Case Officer: George Smith

Recommendation: Refuse

Proposal: Change of use and conversion of 1no agricultural building into 1no self contained dwellinghouse (use class C3) including associated operational development under Part 3 Class Q (a) and (b)

DATE: 7th August 2020

Sketch SK/01 Structural Plan and Section of Former Agricultural Store/Workshop

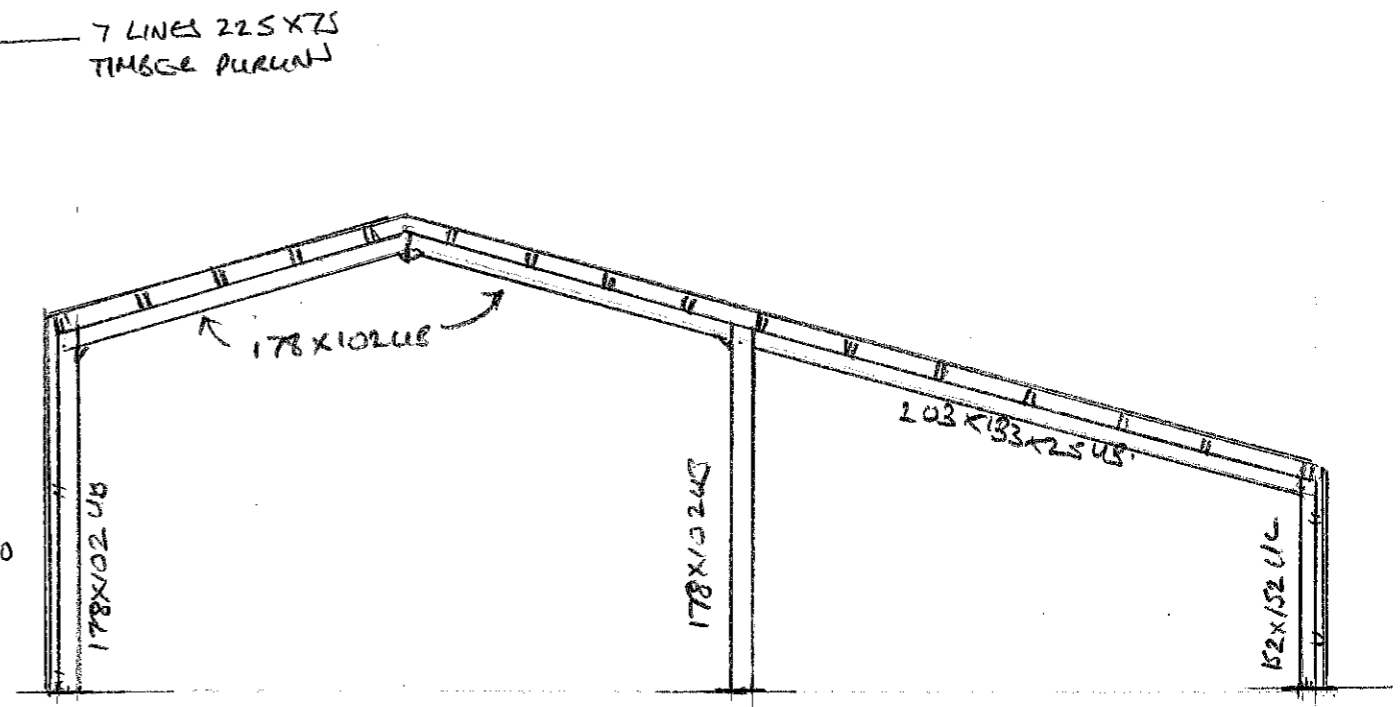
- 8.10. The structural survey states that the existing building is in fair condition and is structurally suitable for conversion to residential use without any strengthening of the building envelope.

- 8.11. Officers do not contest that the existing internal structural frame is sound for the purposes of the existing agricultural use. Upon the officer site visit, it is clearly capable of supporting the existing corrugated metal sheeting, albeit that this sheeting consists of one-layer, certainly not a heavy load to bare. It is rational to conclude

FLOOR PLAN

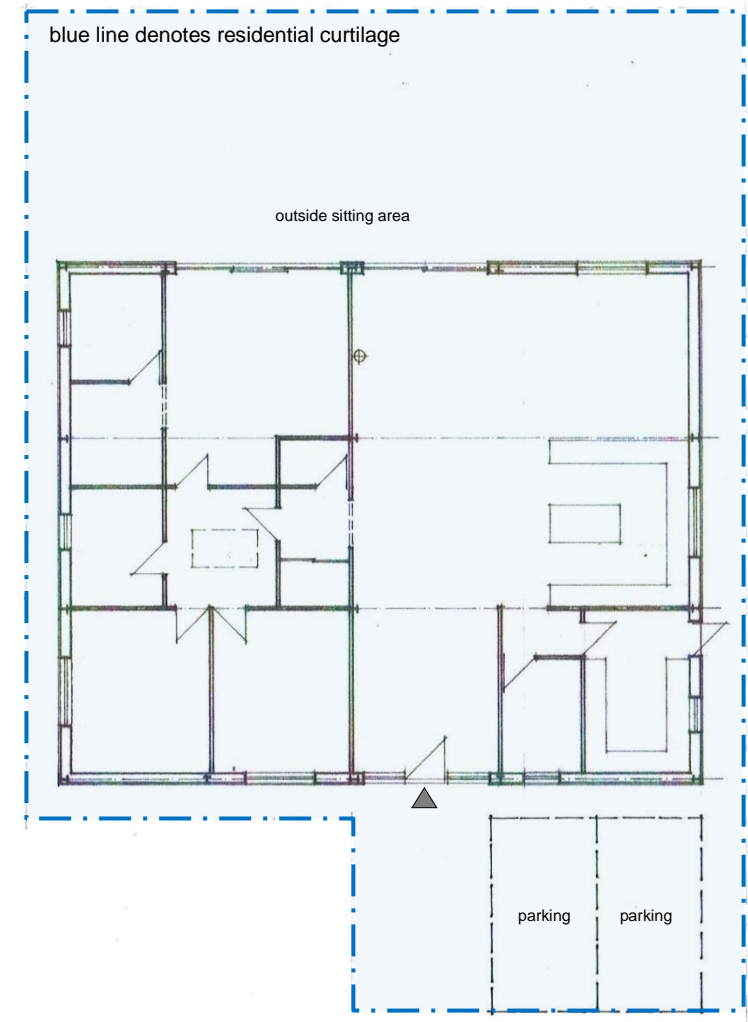
- 8.13. Under this proposal, all of the existing metal sheeting would be removed, leaving the skeleton structure of the building. Following this, the floor plans show a degree of insulation/structure (at least 40mm) in order for the proposed timber cladding to be supported. It is not clear from the plans of what this new internal support would consist. Furthermore, the roof would be removed and replaced.

- 8.15. The windows and doors proposed are not necessarily excessive for a residential use and would, at least in terms of the larger openings, utilise the positioning of the existing barn doors.

NORTH ELEVATION

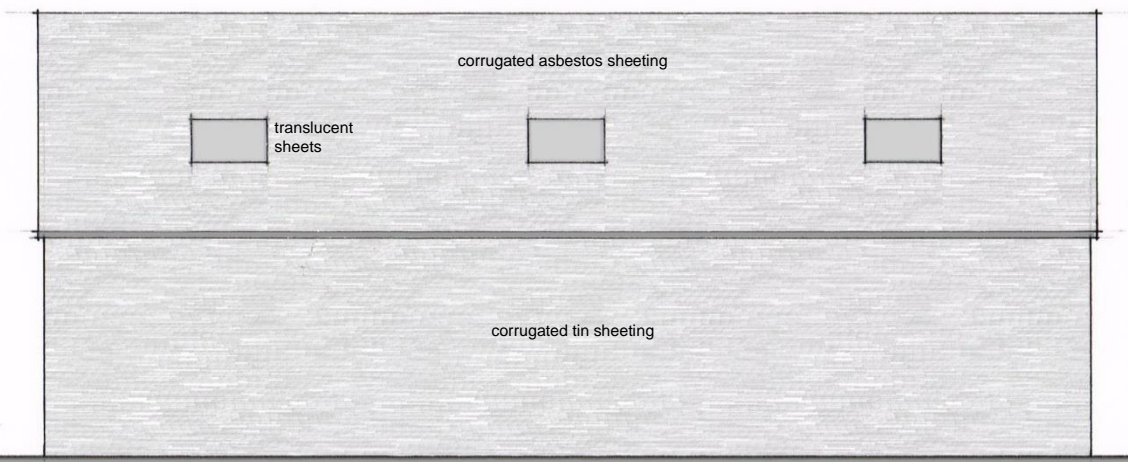
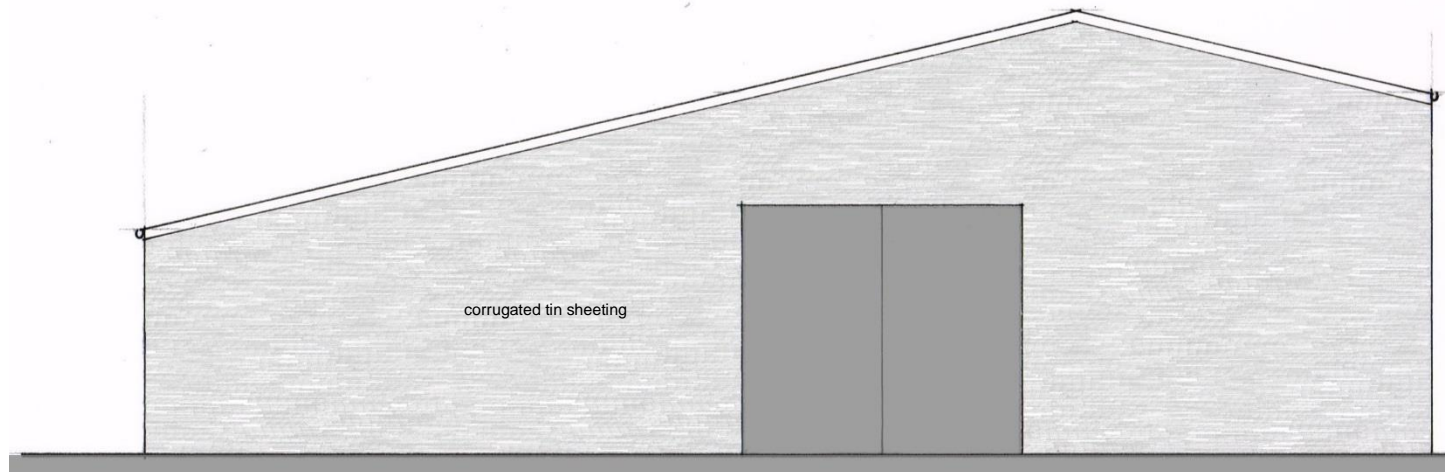
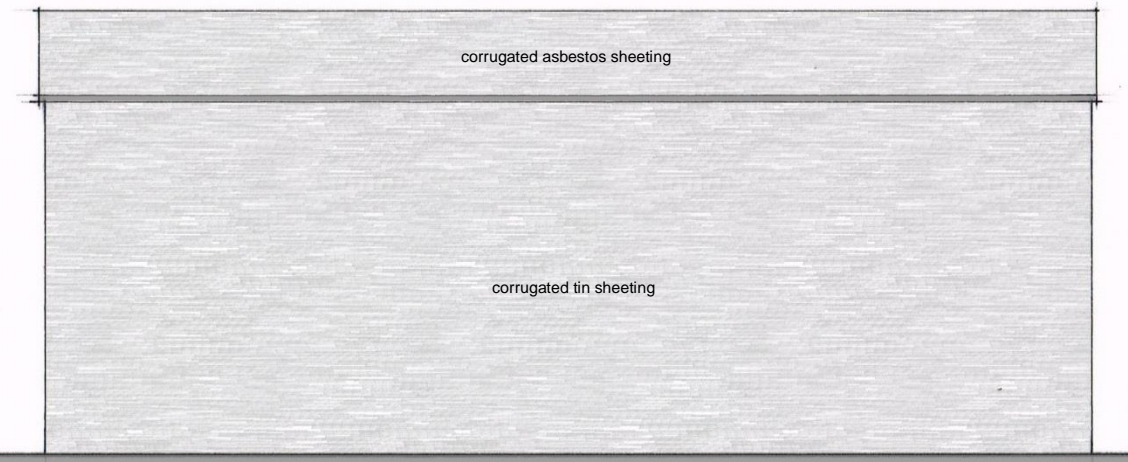
- 8.30. The design of the building, i.e. insertion of windows and timber cladding would detract from its agricultural character but would not fundamentally change the form of the building. Significant alteration of the building is proposed by its very nature, but it is not considered that part Q.2 (f) is not necessarily offended by this, rather that it is relevant under Q.1 (i).
